Application for a Non-Material Amendment Following a Grant of Planning Permission

Number	24
Suffix	
Property Name	
Address Line 1	Broad Lane
Address Line 2	Moulton
Address Line 3	Lincolnshire
Town/city	Spalding
Postcode	PE12 6PN

proposed erection of two 1.5 storey detached dwellings with attached garages, vehicular access and landscaping

H13-0981-24

cdm.	DESIGN
BUILDING REGULATIONS - plot 1 elevations	
1:50 @ A1	OCT 2024
scale(s)	date
113W.2024.13e	CDM
drawing no.

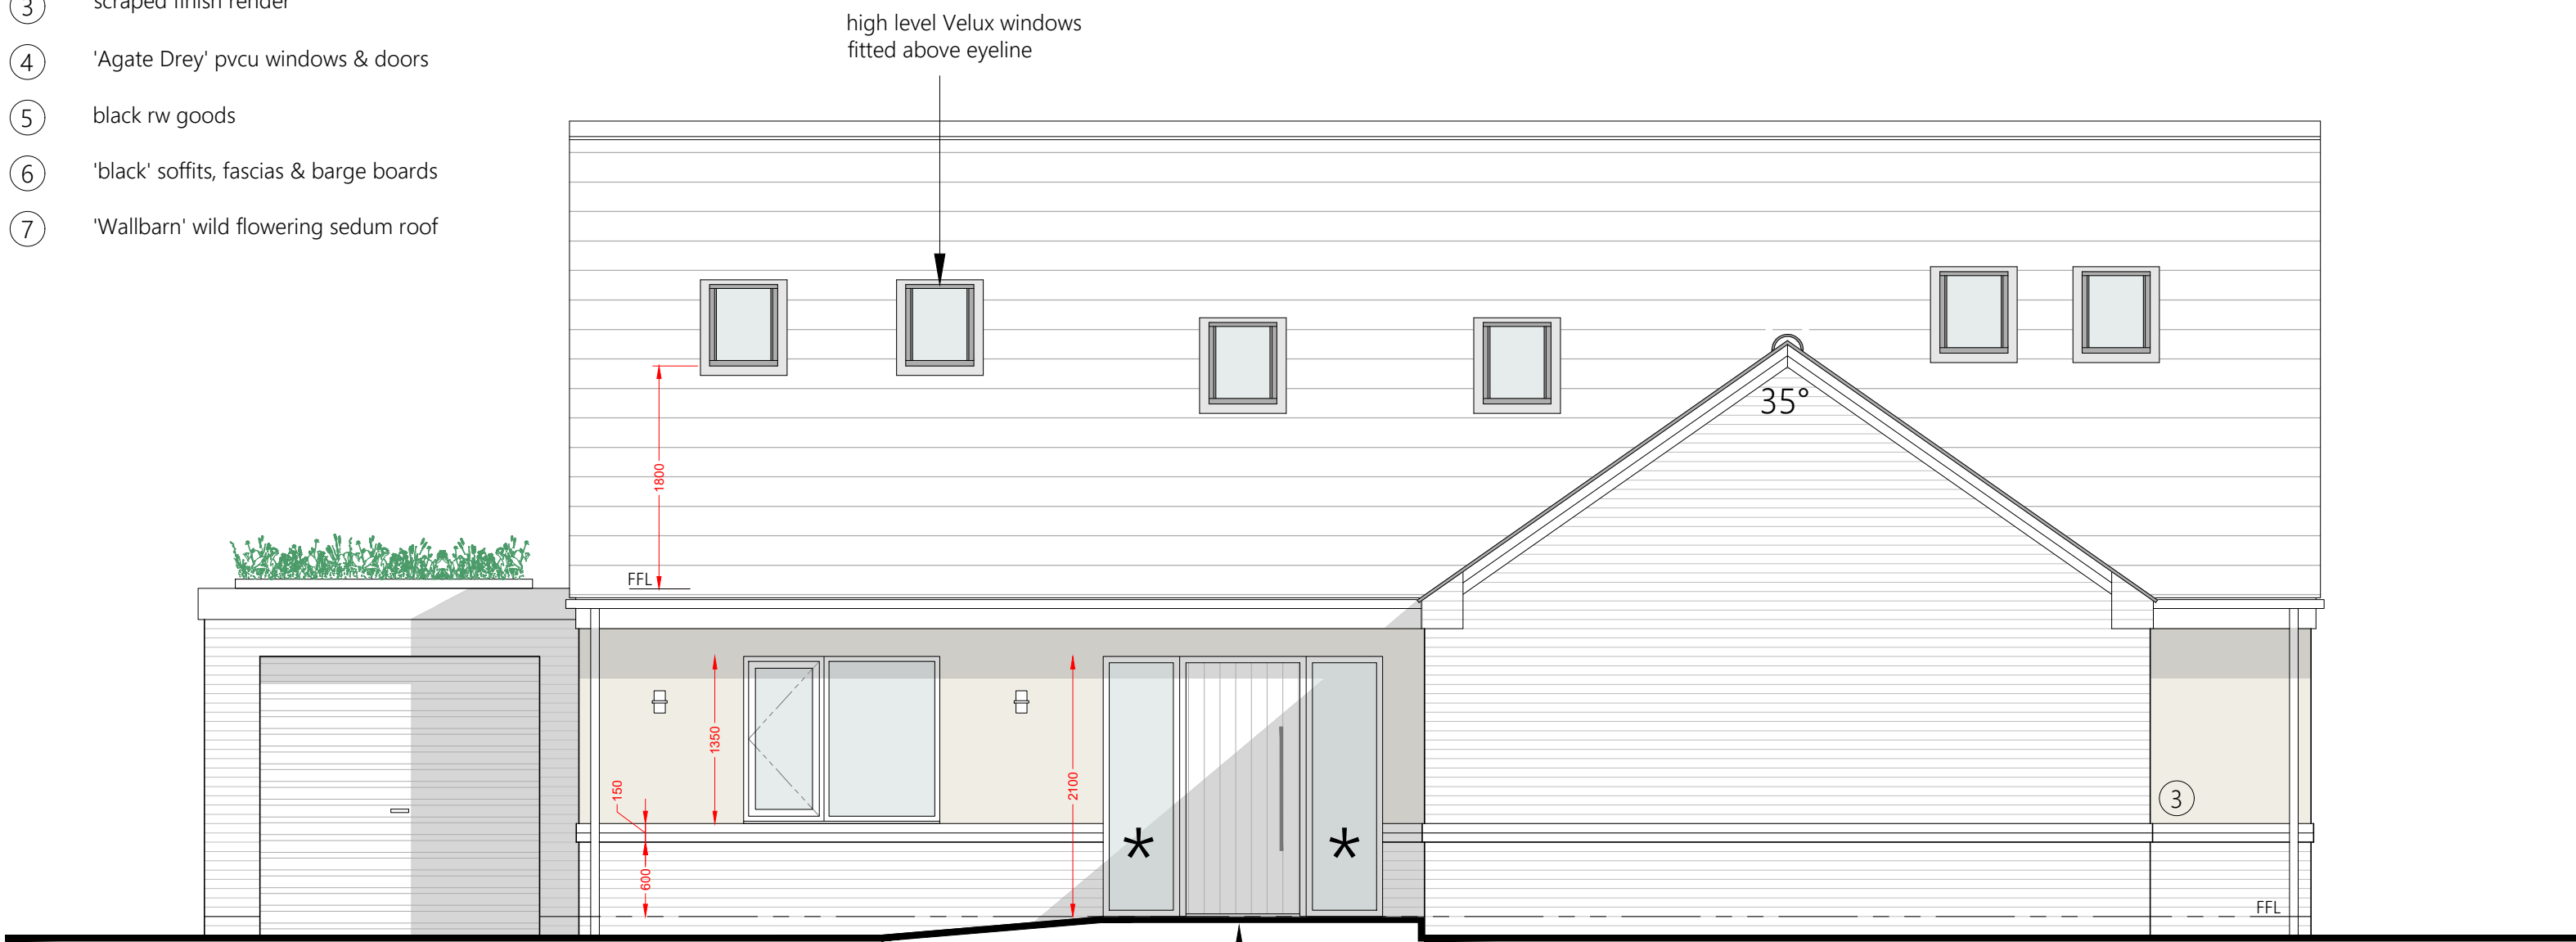
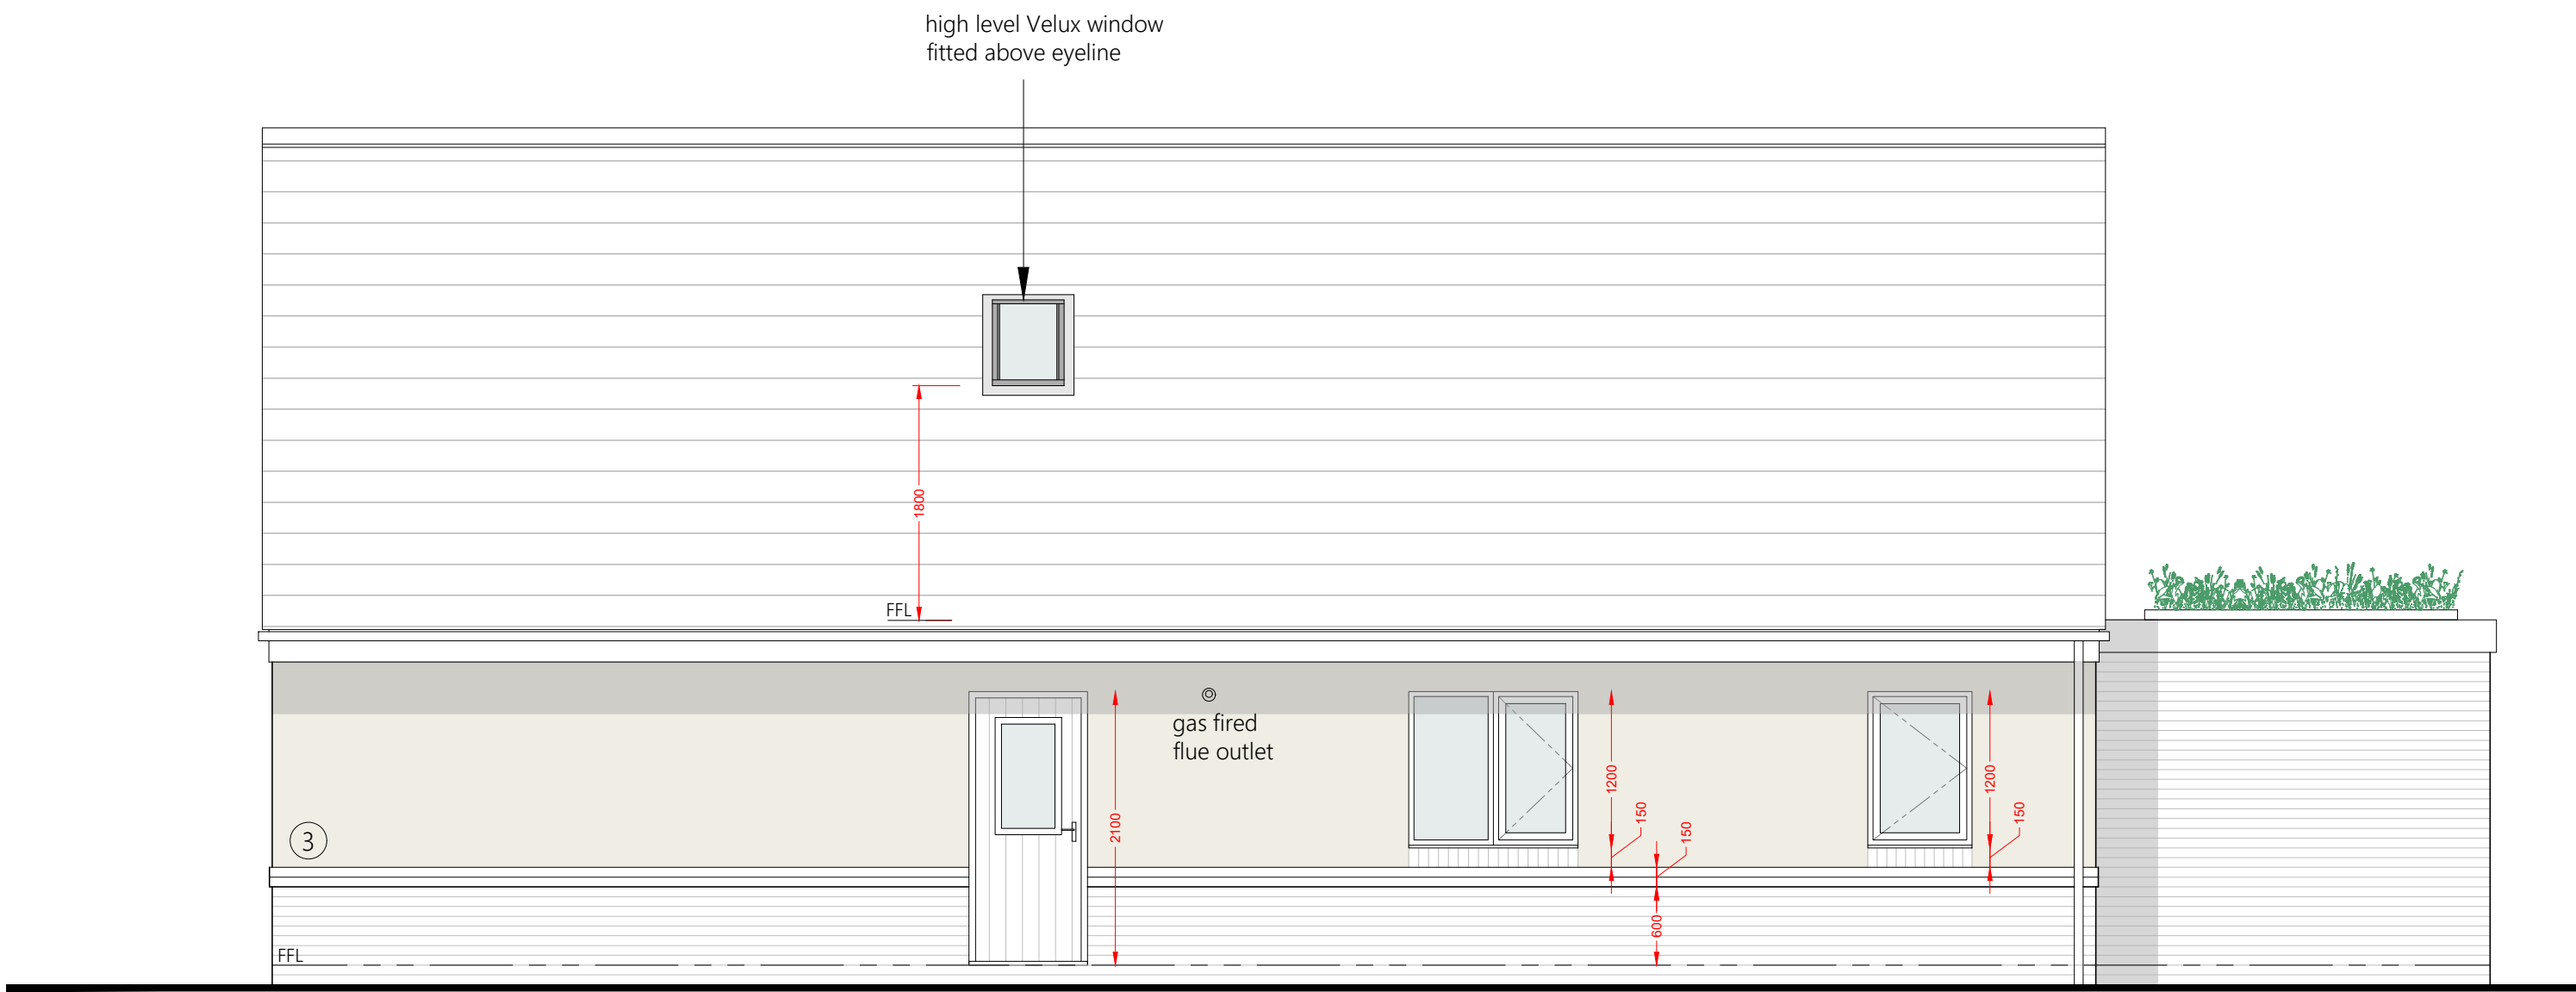
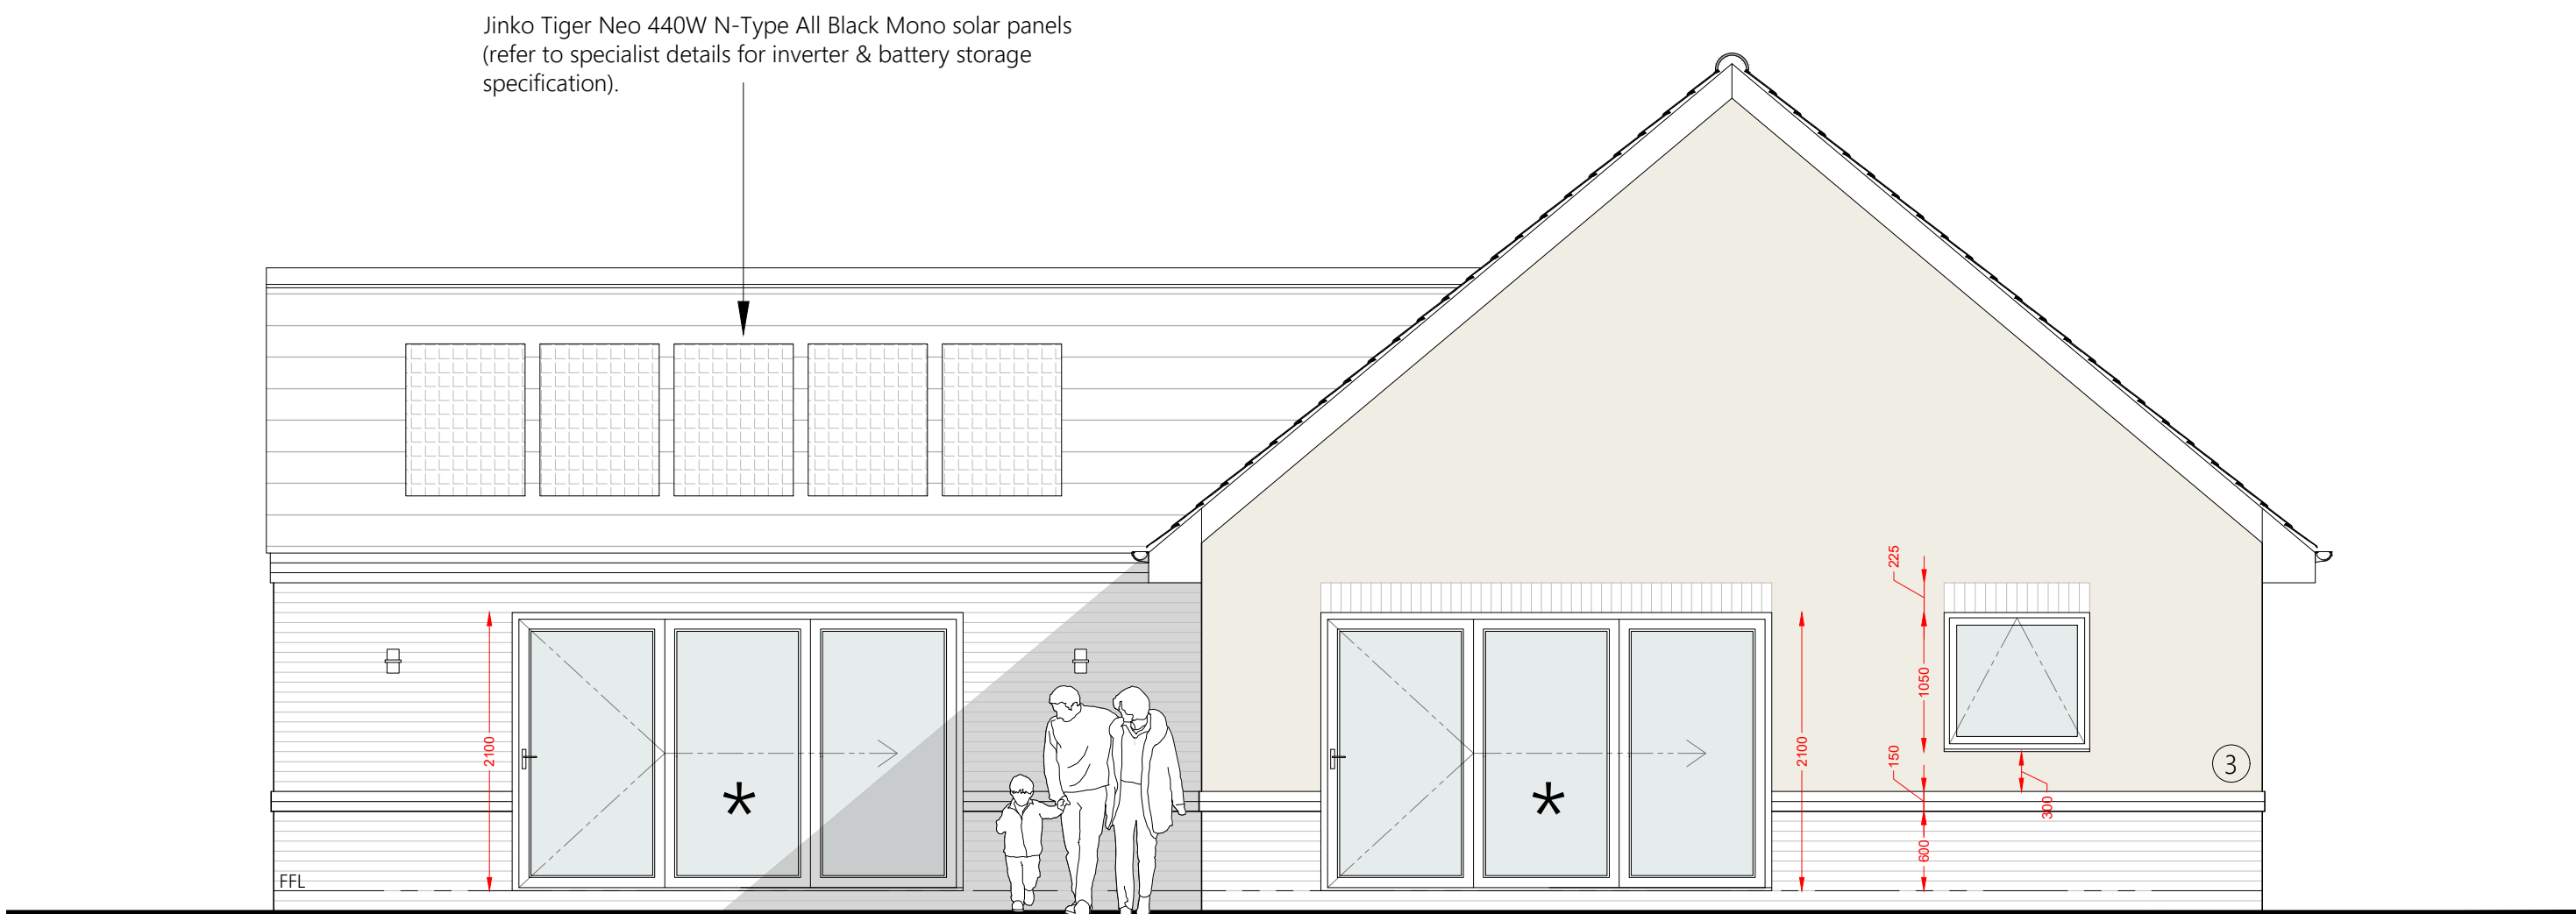
To summarise, the minor, subtle differences are: -

Bedroom 2 window on the rear gable no longer exists.

The ridge height of the roof above the living room is lower than approved.

There are 2 high-level (above eye level) Velux windows to the south elevation serving bed 2 – planning approved showed none.
